# City of Albuquerque

**RE: OFFICE/WAREHOUSE ON AZTEC NE (G15-D53). GRADING AND DRAINAGE PLAN FOR BUILDING PERMIT APPROVAL. ENGINEER'S STAMP DATED AUGUST 6, 1999.**

GRADING/DRAINAGE PLAN FOR OFFICE/WAREHOUSE

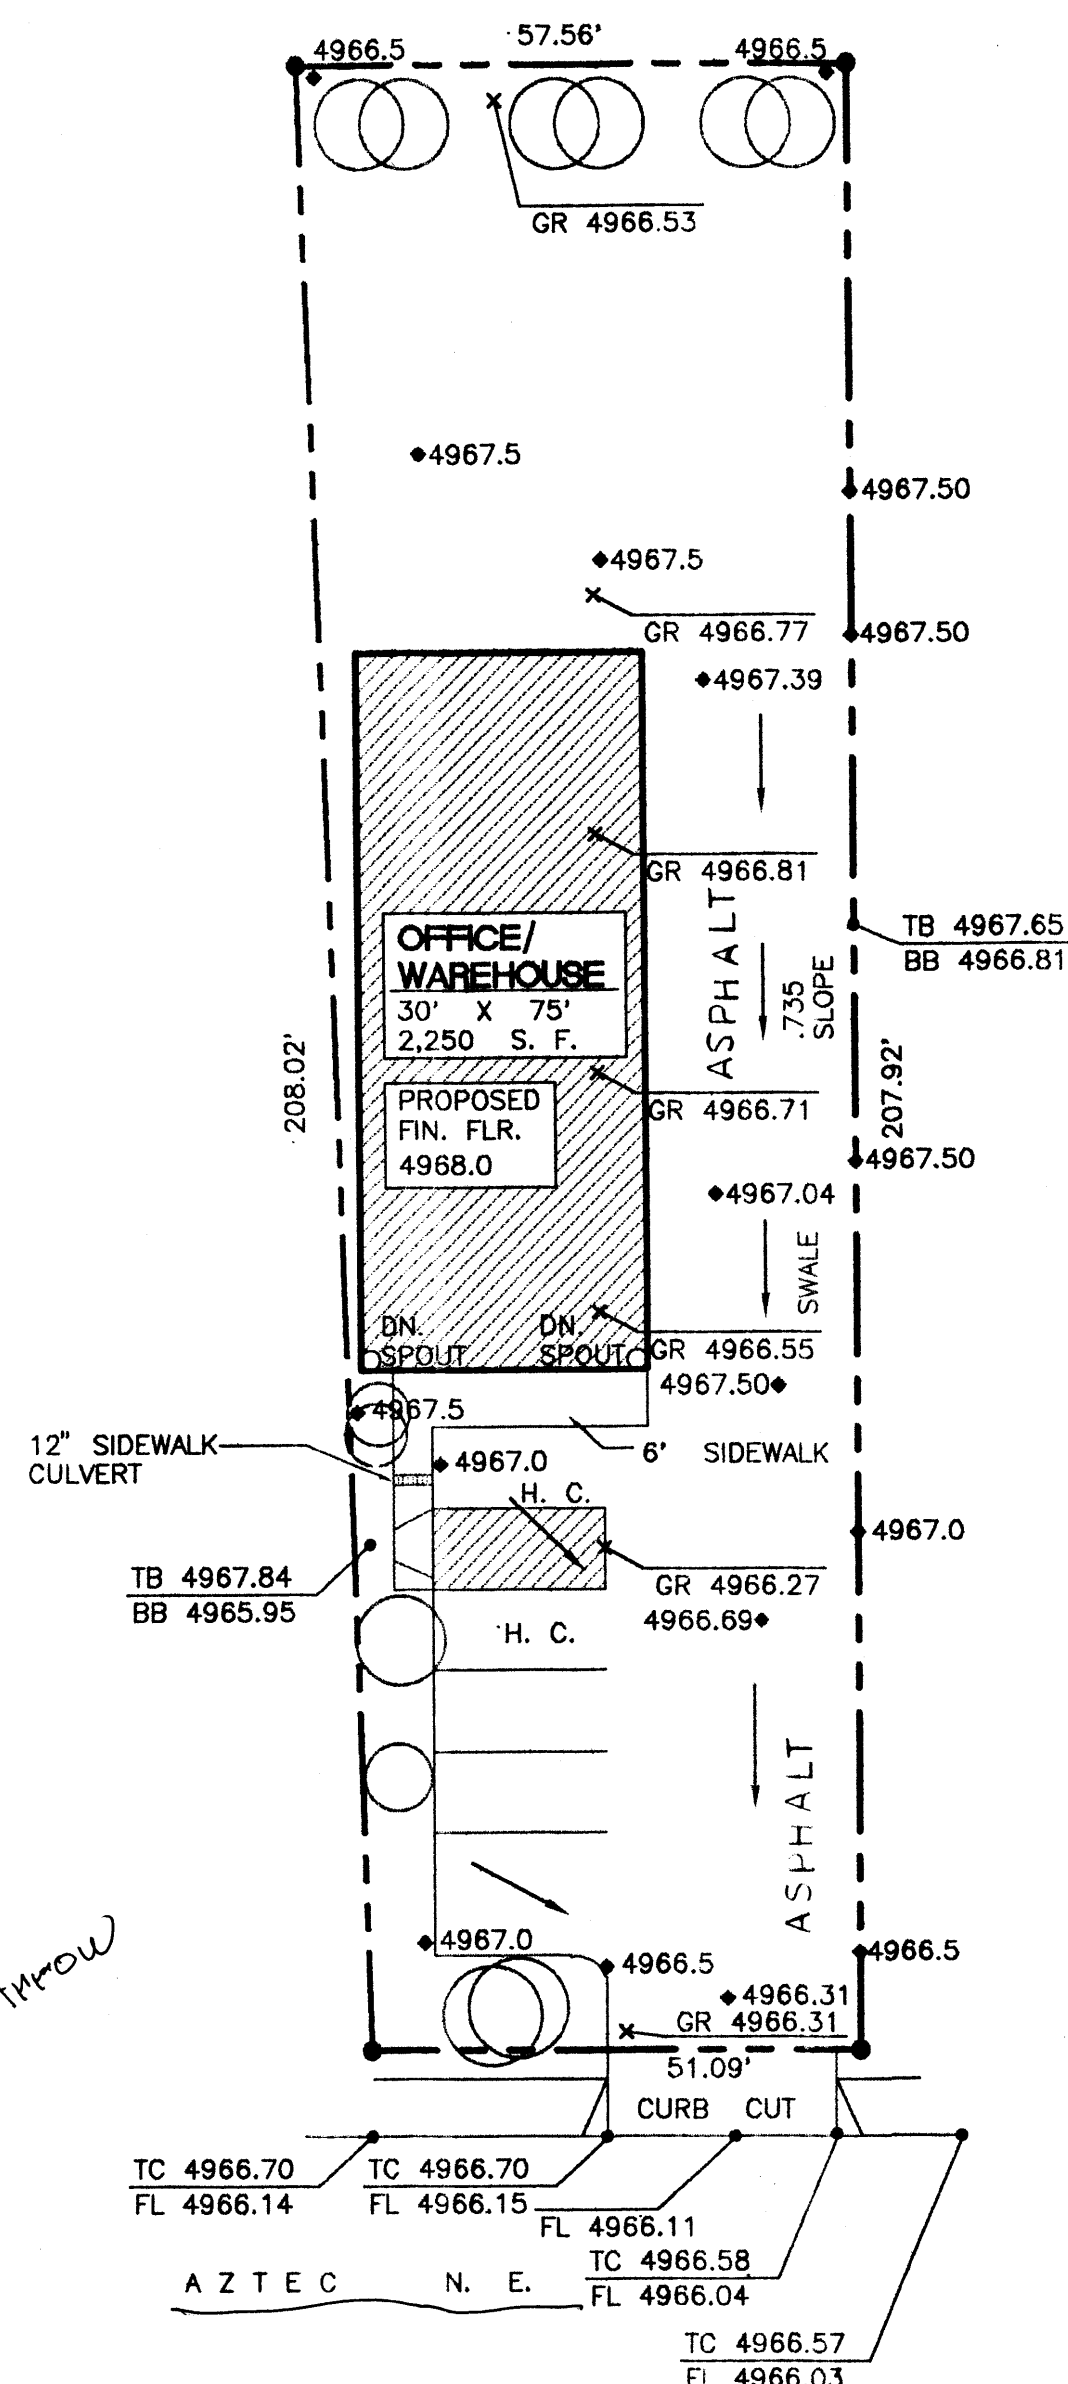
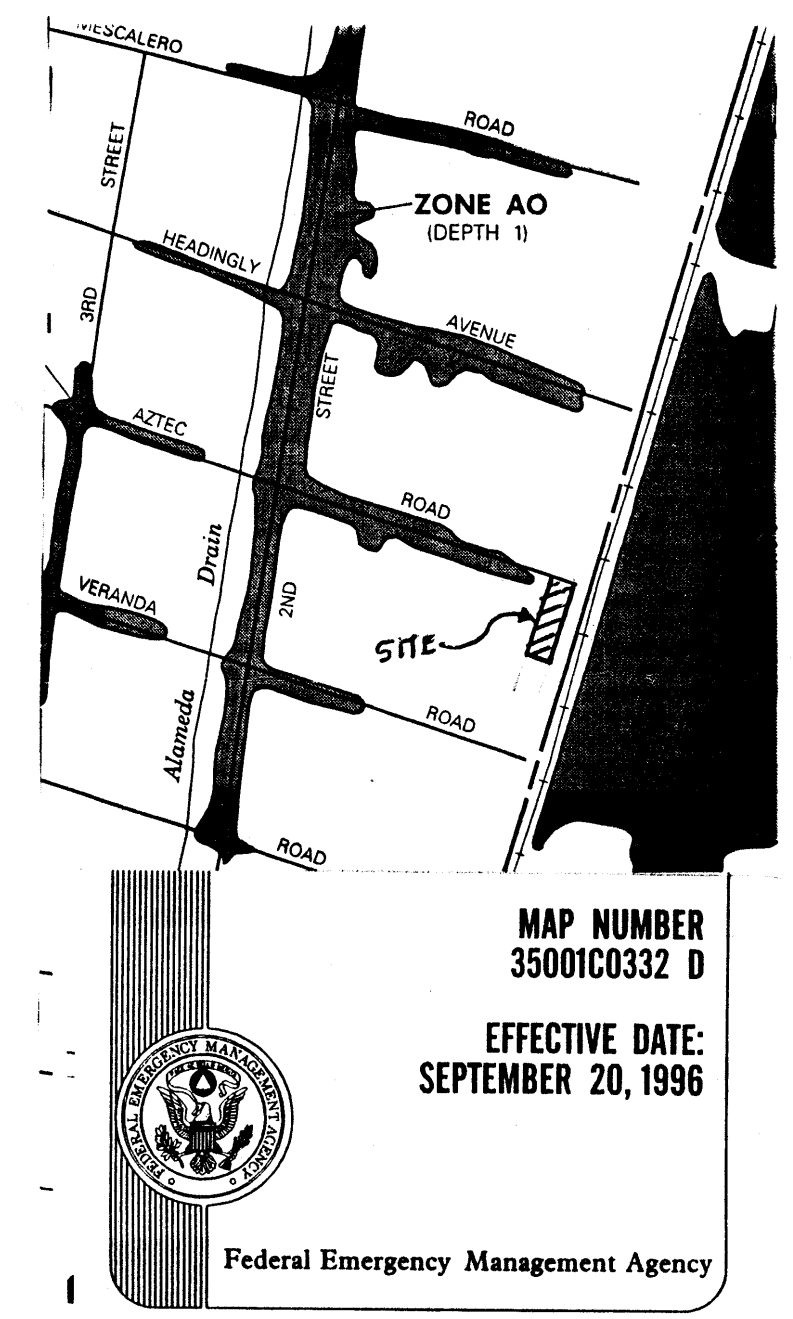
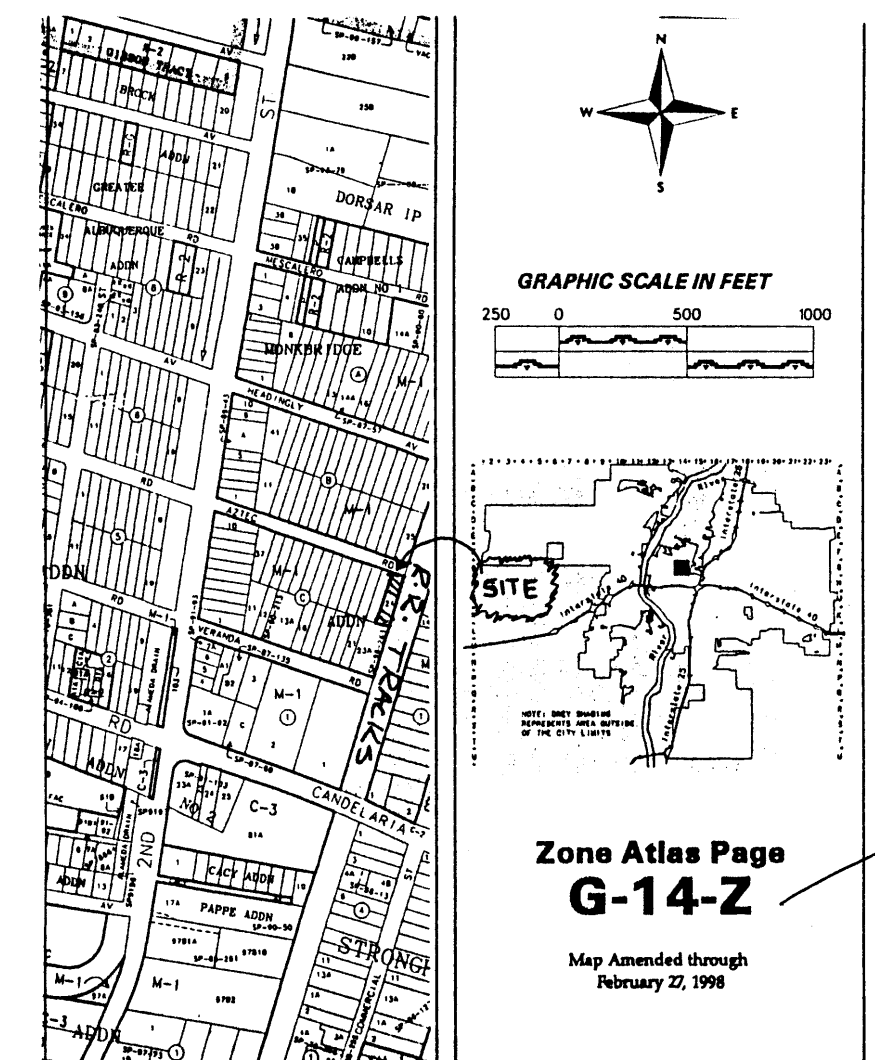
C.O.A. has recorded project in Zone Atlas G-15 and not G-14 as on your submittal. Show North Arrow on Site Plan.
